From: Thomas Callaway
Sent: 07 November 2013 13:19
To: Planning.Responses
Subject: RE: Planning Consultation on: BE/91/13/

Engineers comments in respect to surface water drainage:

APPLICATION BE/91/13/

Description of Works: Erection of 1 No. four-bedroom detached bungalow

DRAWING TITLE			
Proposed Housing Development Plot B off Chichester Road Proposed Site, Block & Location Plan			
DATE	SCALE	DRAWN BY	EC
Sept '13	as indicated	CHECKED BY	mf
JOB NO.	DRAWING NO.	REVISION	
1313	2.06

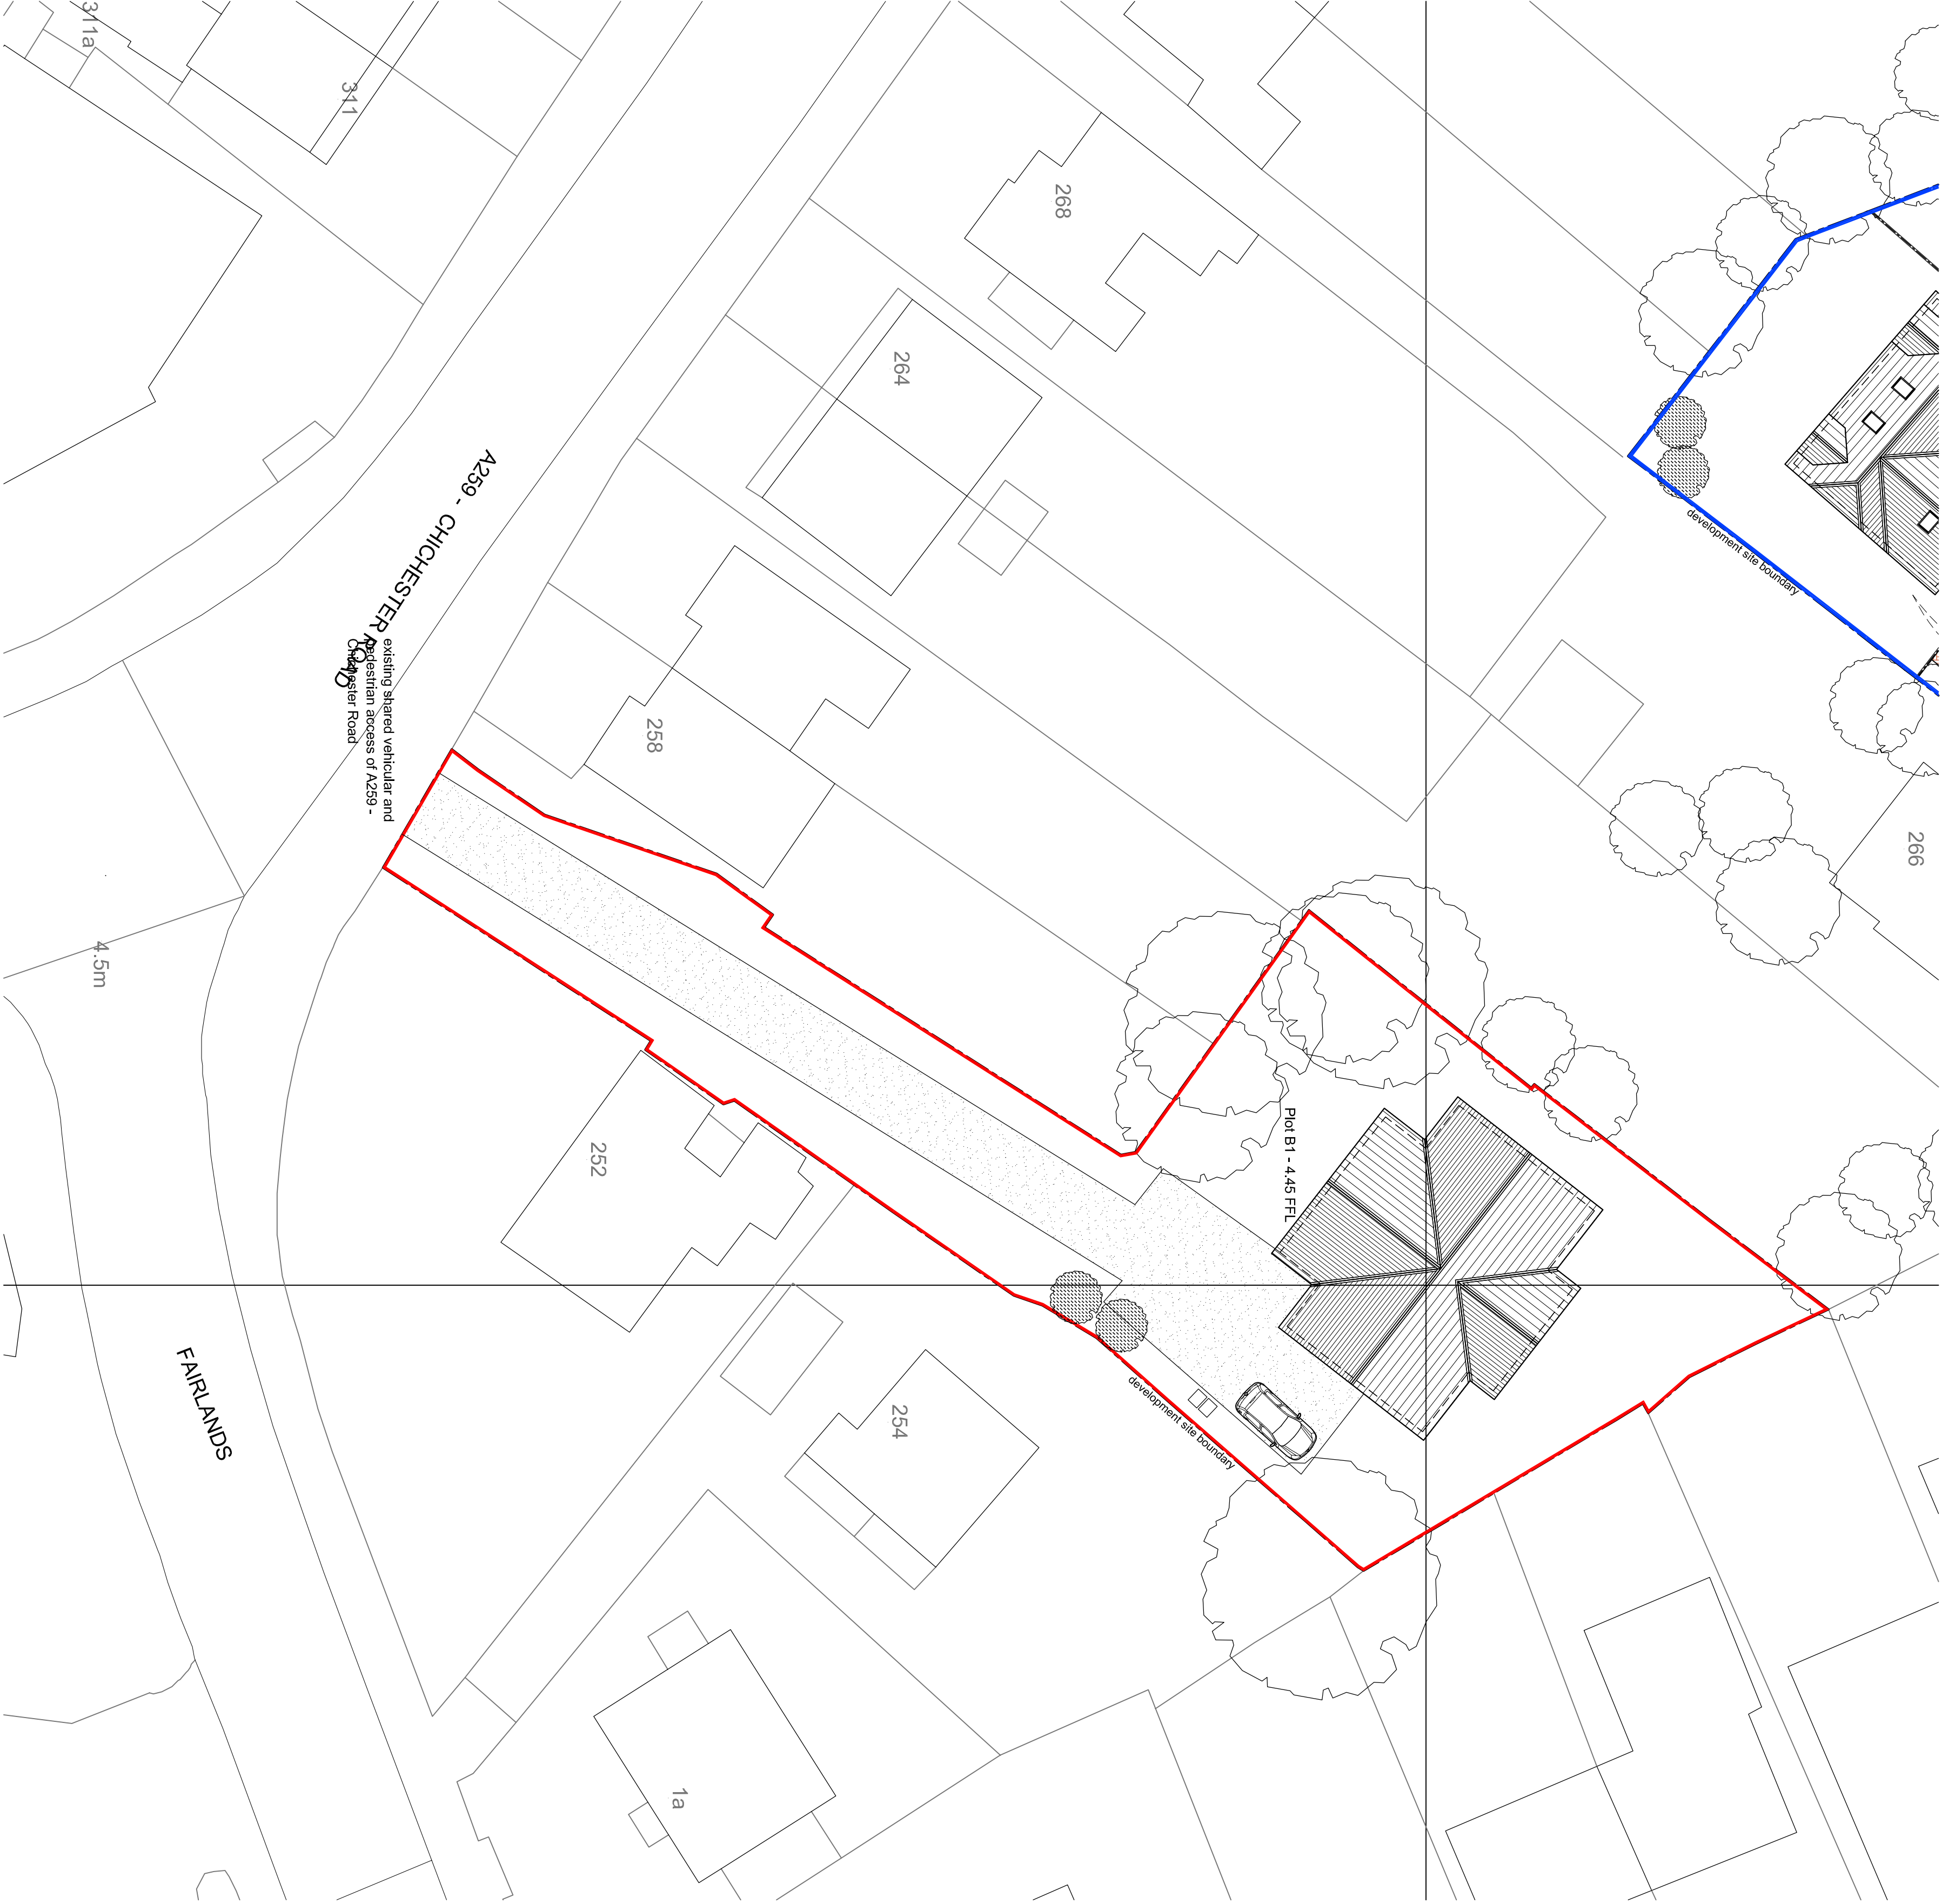
A ditch or culverted system may run along the eastern boundary of the site. This must be investigated and maintained if present. Discharge of surface water to a watercourse would require land drainage consent from the lead local flood authority.
